FW: M/32/26/PL - 60 Sea Way - SWS Capacity Check Response – DSA000055495

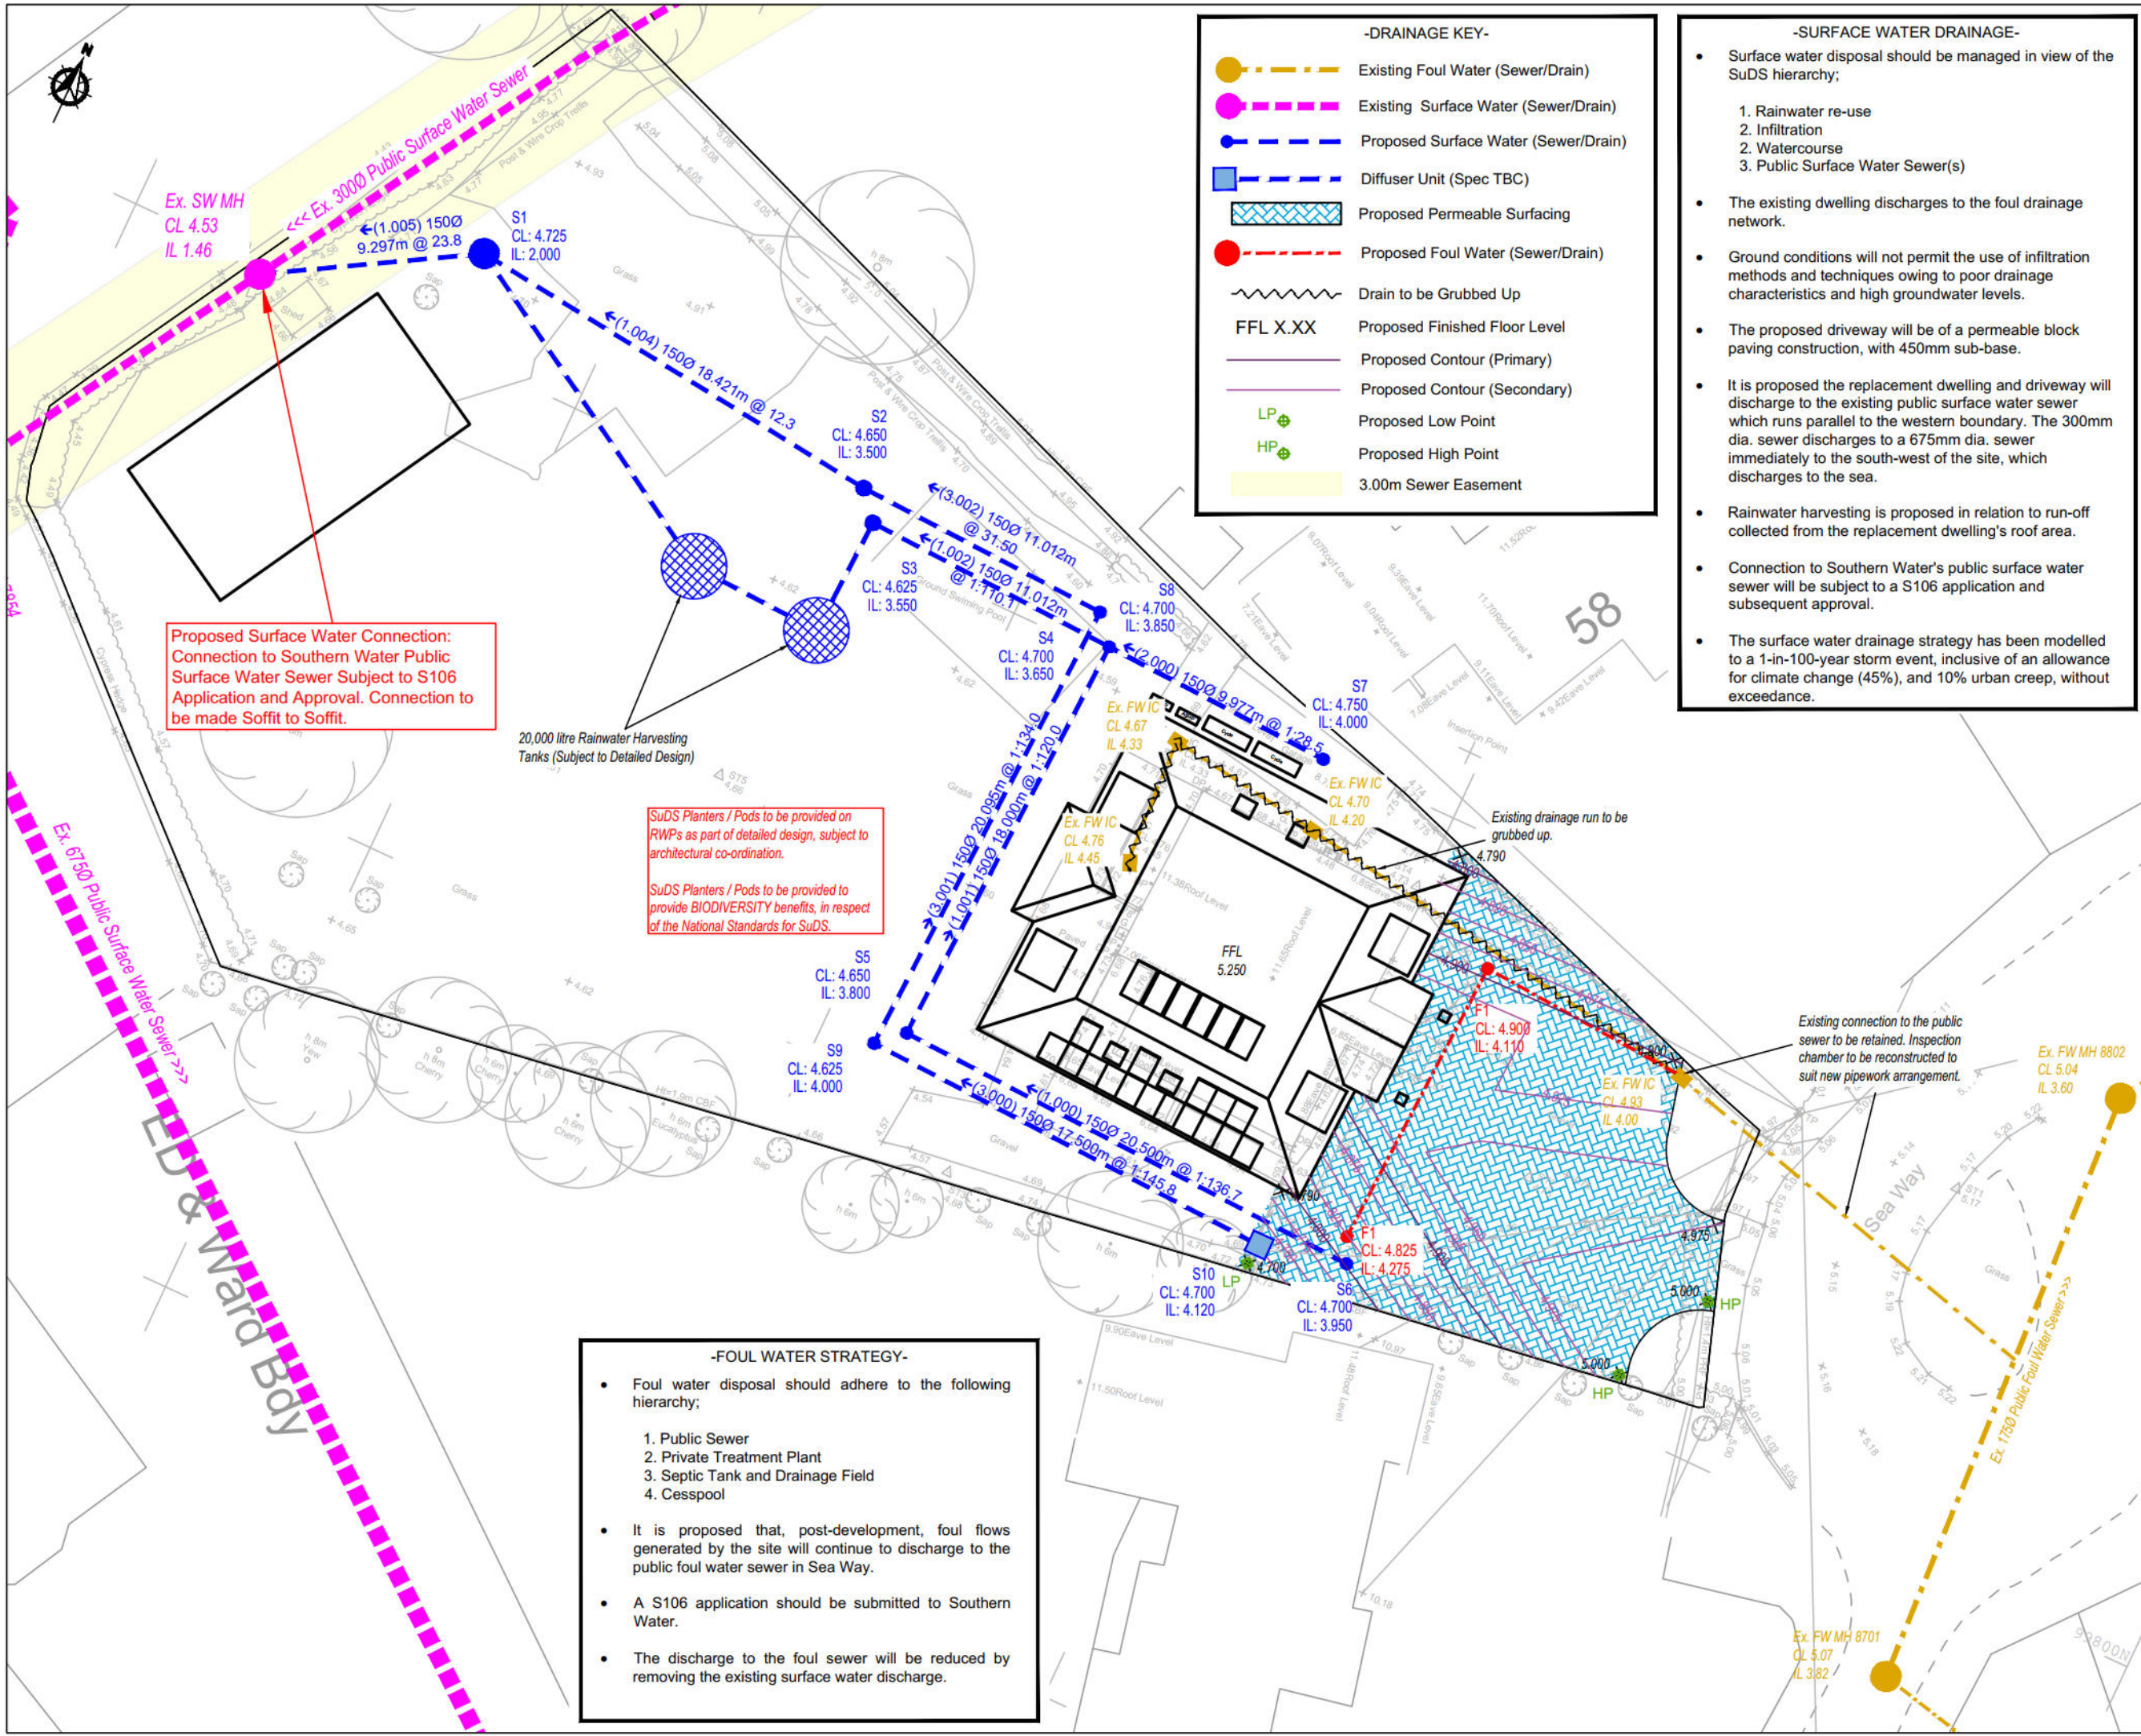
1. Flow control @2l/s between S1 and public sewer.
2. Evidence to suggest 40m³ (2x 20,000 litre rainwater harvesting tanks) provide attenuation for 1 in 100 yr +CC rainfall events with a 2 l/s flow control.
